# Exhibit 8

December 28, 2020

Re: Constantine Short Plat  
8817 SE 44<sup>th</sup> St  
Mercer Island, Washington  
SUB 20-004

This letter is provided at your request to comment on whether there is a seismic hazard at the subject property and confirm that the proposed building pad locations minimize the disturbance of the existing, natural topography.

CONSTANTINE PROPERTY BOUNDARY AND TOPOGRAPHIC SURVEY

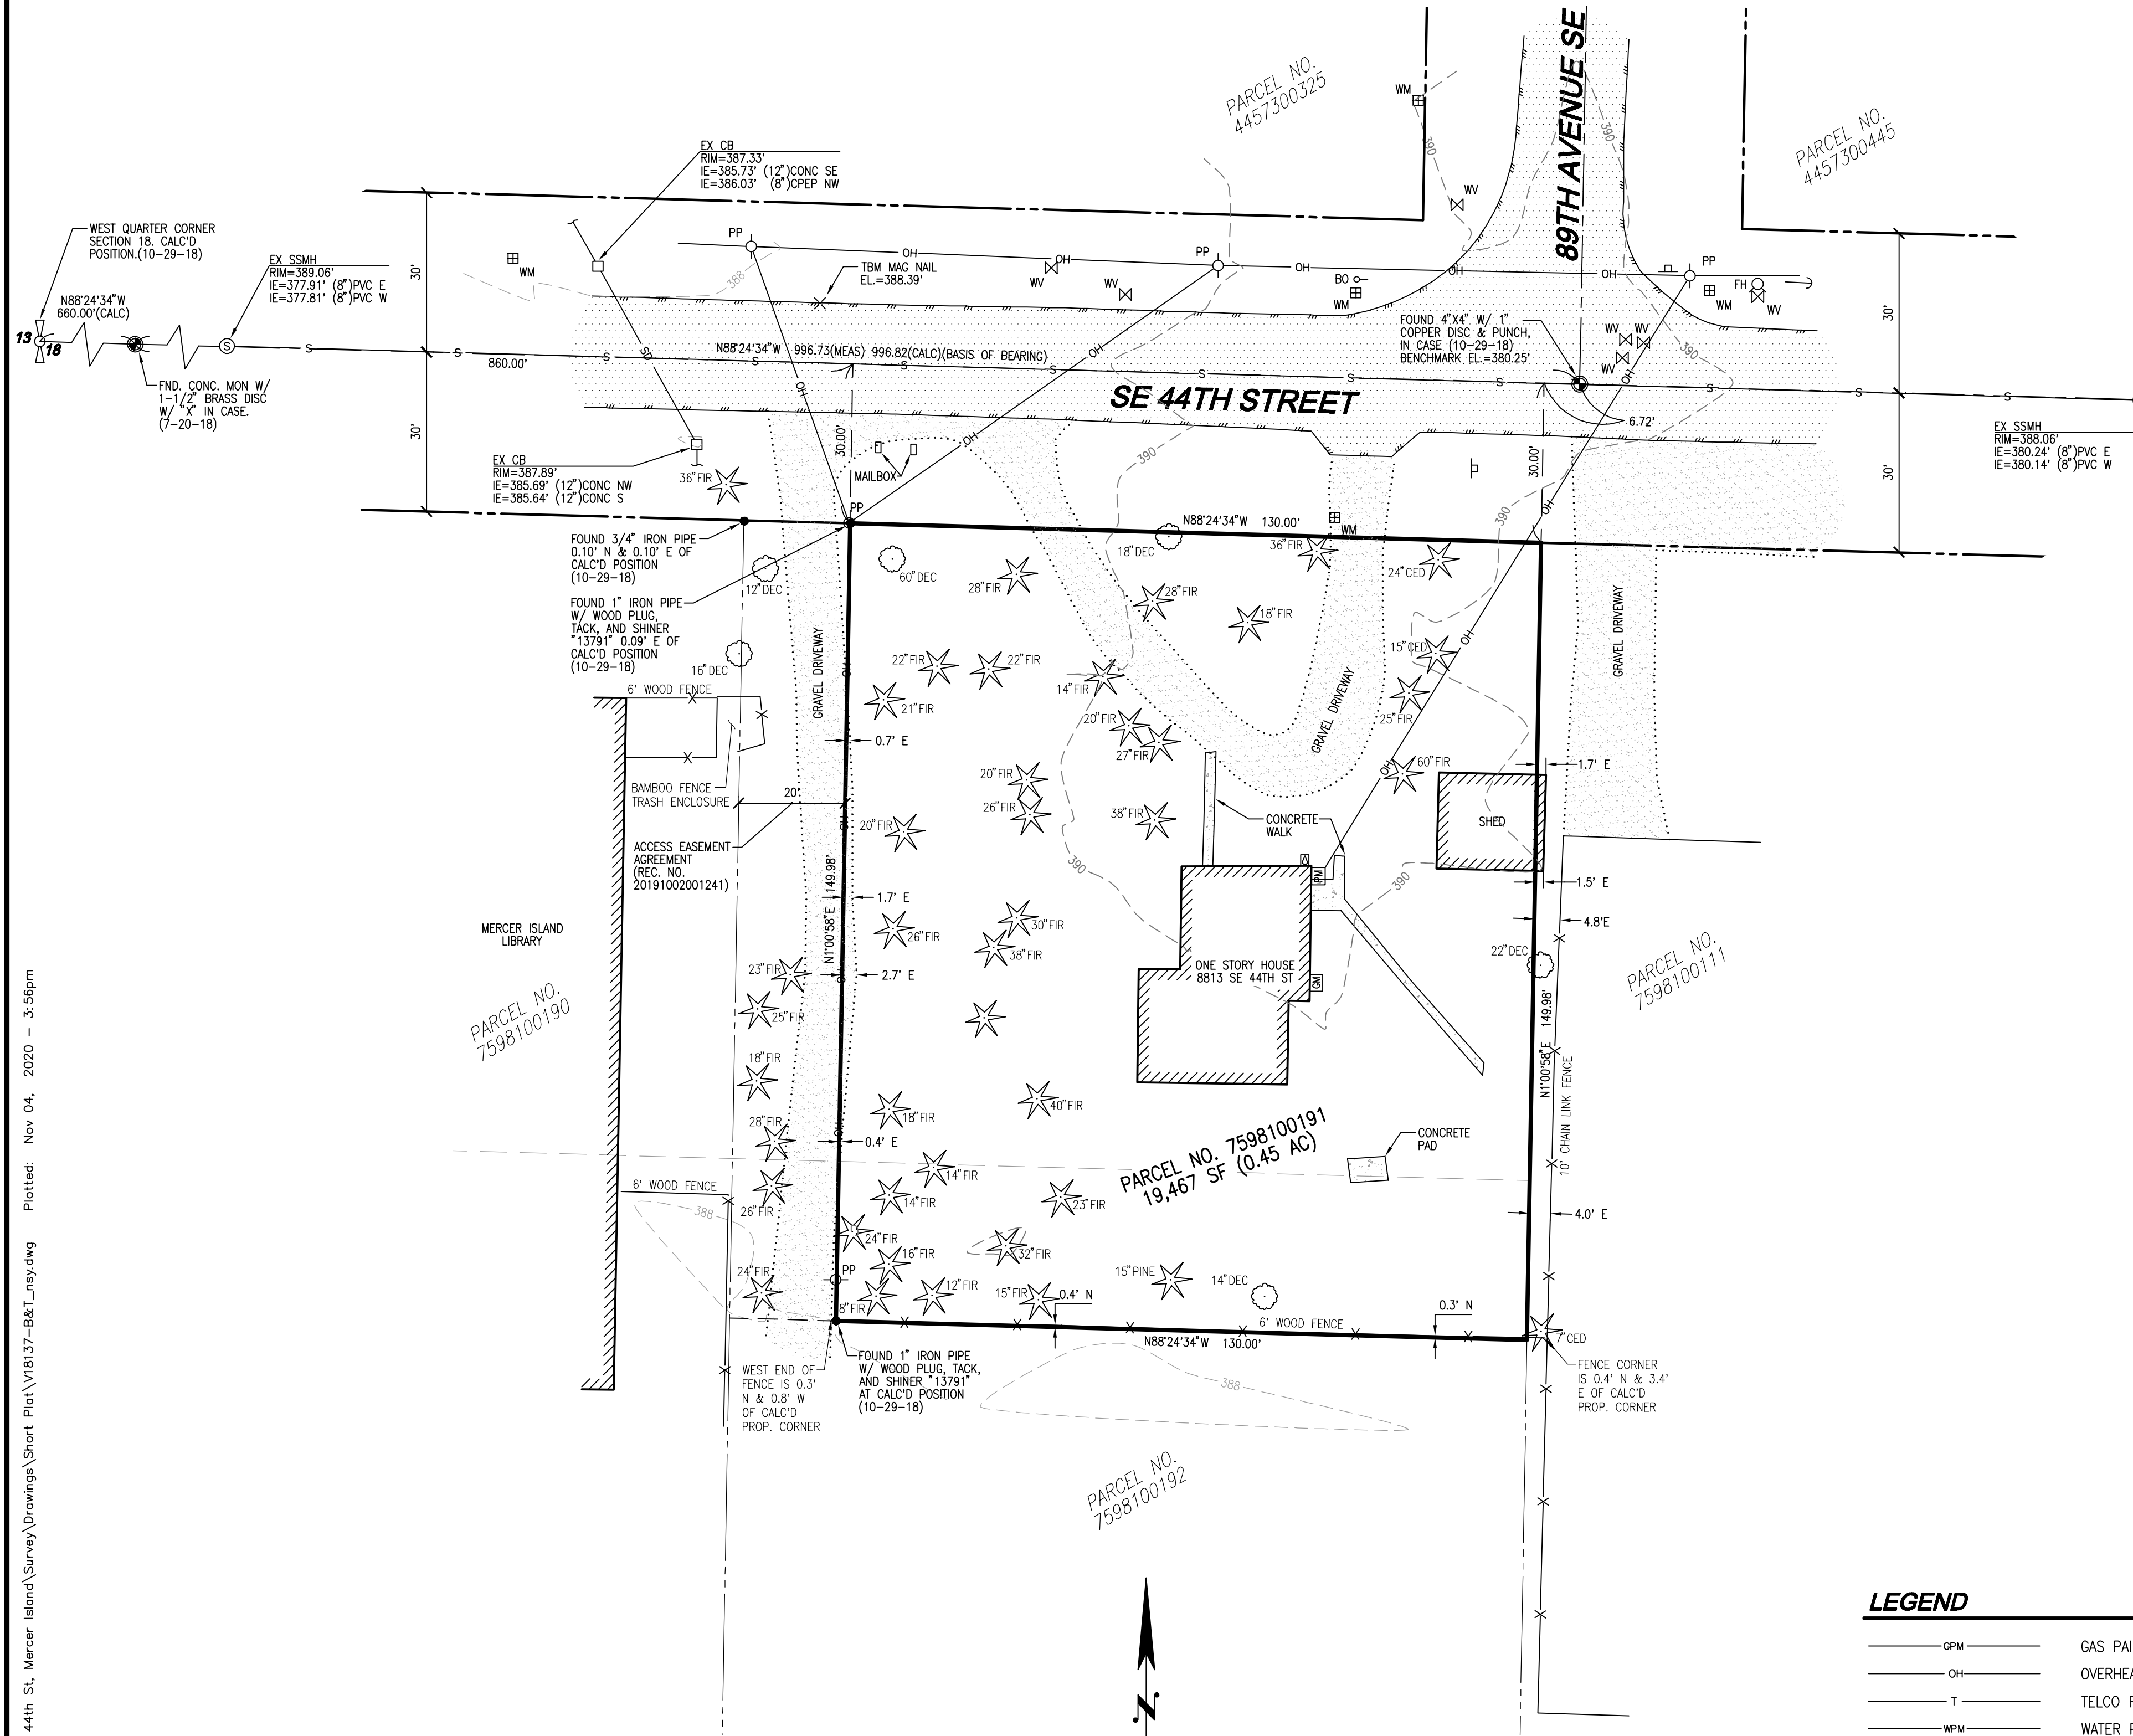
The topographic site plan provided in the plan set (Offe Engineers, November 5, 2020) indicates less than a 2-foot elevation change across the site. The conceptual grading/utility plan shows limits of excavations confined to distances ranging from 2 to 7 feet away from proposed building pads and utility locations.

SHEET
7 OF 7

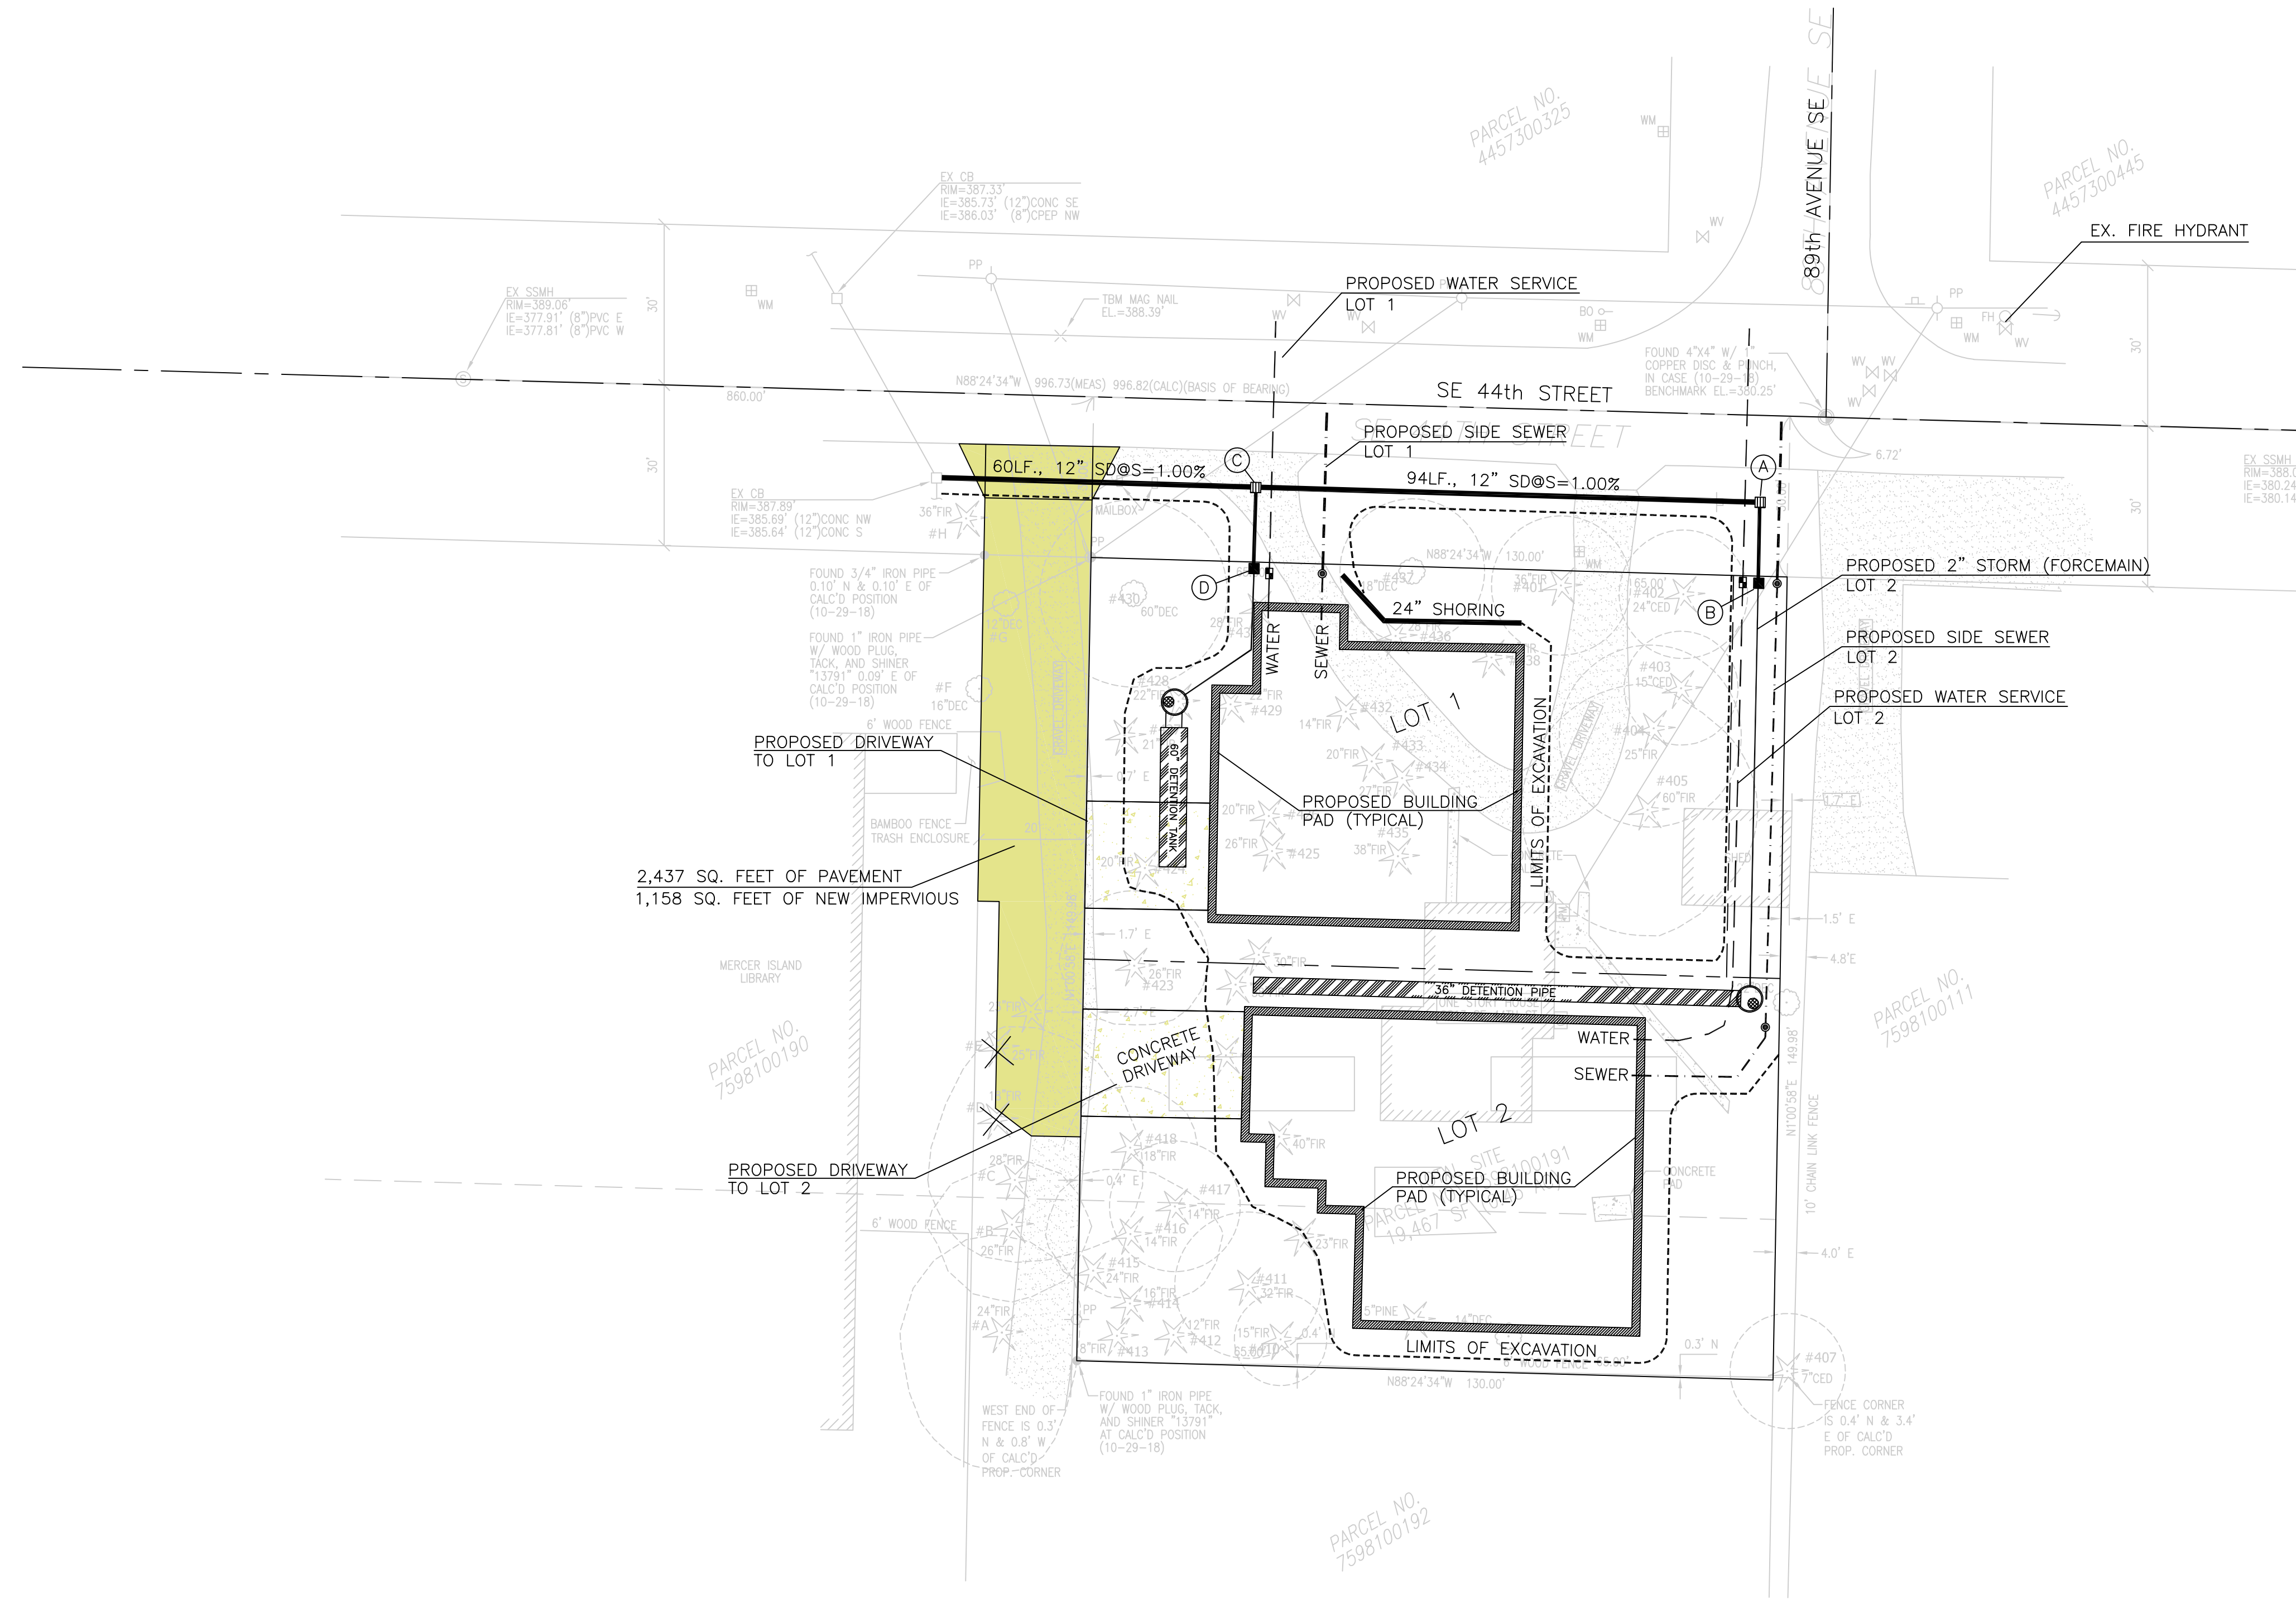
One area to note however is the location of the proposed side sewer along the east property line that will connect to the existing sewer line in SE 44<sup>th</sup> Street. The sewer manholes in SE 44<sup>th</sup> Street have invert elevation information ranging from 380 to 378 feet (east to west). This is 10 to 12 feet deeper than the existing site grade of elevation 390 feet.

The proposed location of the side sewer is only two feet from the east property line. To connect to the existing sewer line in SE 44<sup>th</sup> Street, the depth of the side sewer may be 10 feet or more. An open cut excavation conforming to the geotechnical engineer's recommendation of no steeper than 1 horizontal to 1 vertical (1H:1V) would require a construction easement from the property owner to the east or temporary excavation shoring so as not to encroach on the adjacent property.
